Submission for Job: #6010 SSD 6010 - One Residential Building (Student Accommodation) within Darling Drive Plot  
[https://majorprojects.affinitylive.com/?action=view\\_job&id=6010](https://majorprojects.affinitylive.com/?action=view_job&id=6010)

**SSD 6010 - One Residential Building (Student Accommodation) within Darling Drive Plot**

**23 July 2013**

SHADOW DIAGRAMS: PERSPECTIVE, SHOWING THE PEAK, WINTER SOLSTICE

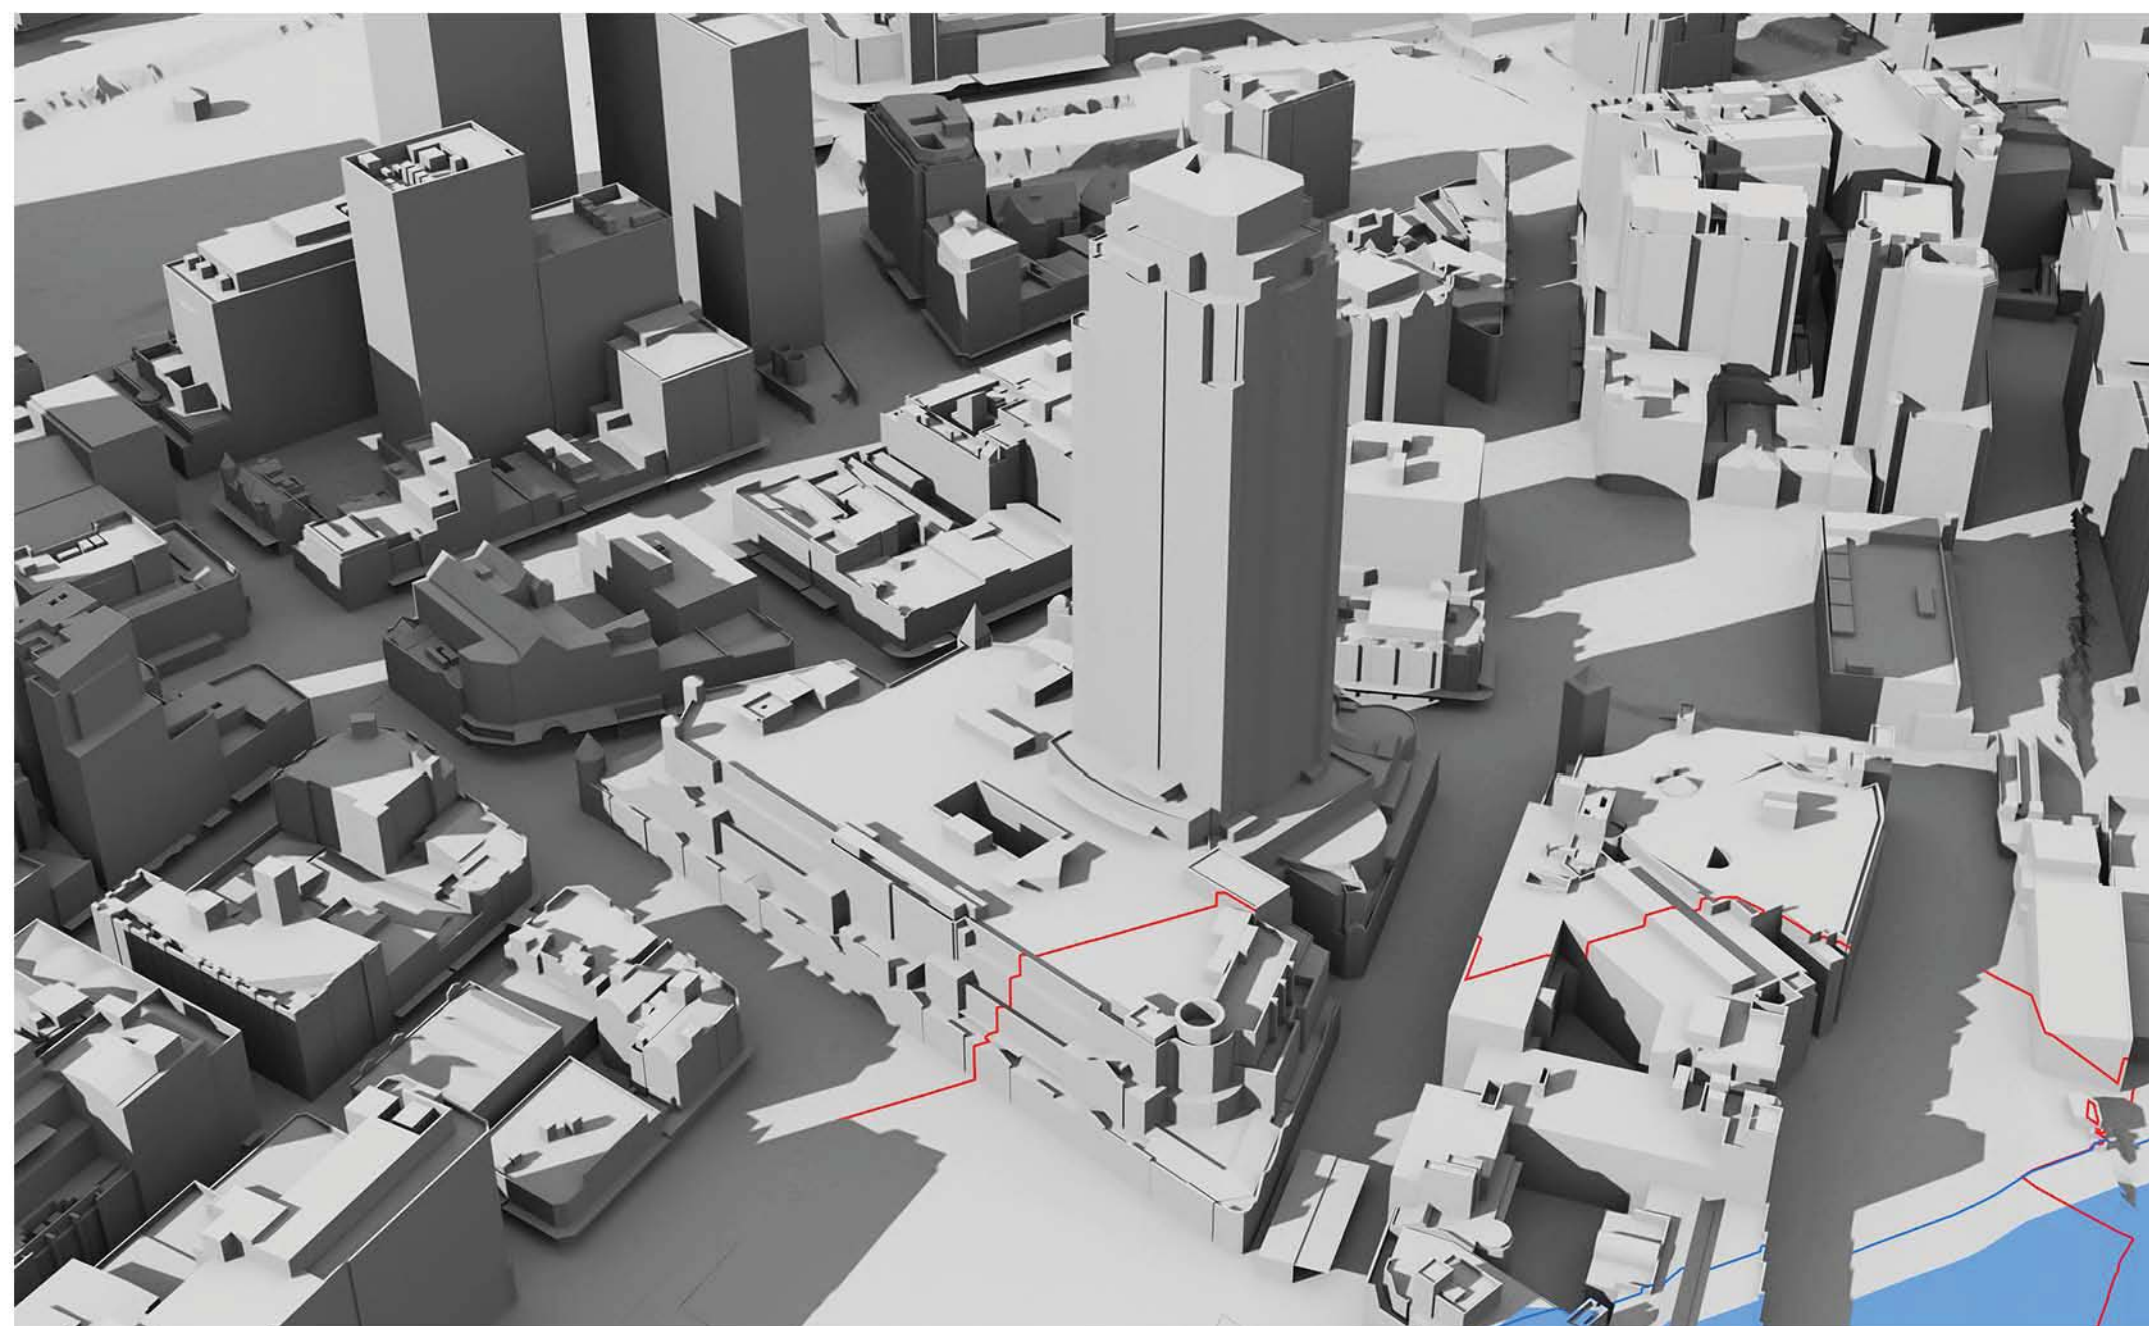
At 9am, 10am and 11am the west façade is totally in shadow due to other parts of The Peak building itself.

At 12pm there is still substantial existing shadowing on the west façade caused by the irregular shape of the west facade.

At 1pm the existing shadowing has been substantially removed, but not totally removed.

It can be concluded that some single aspect apartments on the west façade and some south-west dual aspect corner apartments currently receive less than 2 hours direct sunlight to habitable rooms and 50% of the private open space between 9am and 3pm on 21 June.

By 2pm the existing shadowing has been totally removed, but that is too late to achieve two hours of direct sunlight before 3pm.

At 9am, 10am and 11am the west façade is totally in shadow due to other parts of The Peak building itself.

At 12pm there is still substantial existing shadowing on the west façade caused by the irregular shape of the west facade.

At 1pm the existing shadowing has been substantially, although not entirely, removed. However, overshadowing of lower levels of the west façade by the concept proposal parameter plan shadows for the N,NE and SE plots has already started.

By 2pm the existing shadowing has been totally removed. However, overshadowing of the west façade by the SSDA4 and SSDA5 buildings has appeared and risen further up the west façade than the concept proposal parameter plan shadows for the N,NE and SE plots, which is still present.

At 3pm, the proponent states correctly that 45-45% of the western façade is overshadowed by the SSDA4 and SSDA5 buildings.

It can be concluded that, as a result of combination of the proposed development with existing shadowing of the west façade, some single aspect apartments on the west façade and the south-west dual aspect corner apartments which currently receive less than 2 hours direct sunlight to habitable rooms and 50% of the private open space between 9am and 3pm on 21 June will suffer additional overshadowing. It is beyond our skills to count the number of such apartments. We note that the proponent has made no attempt to do so.
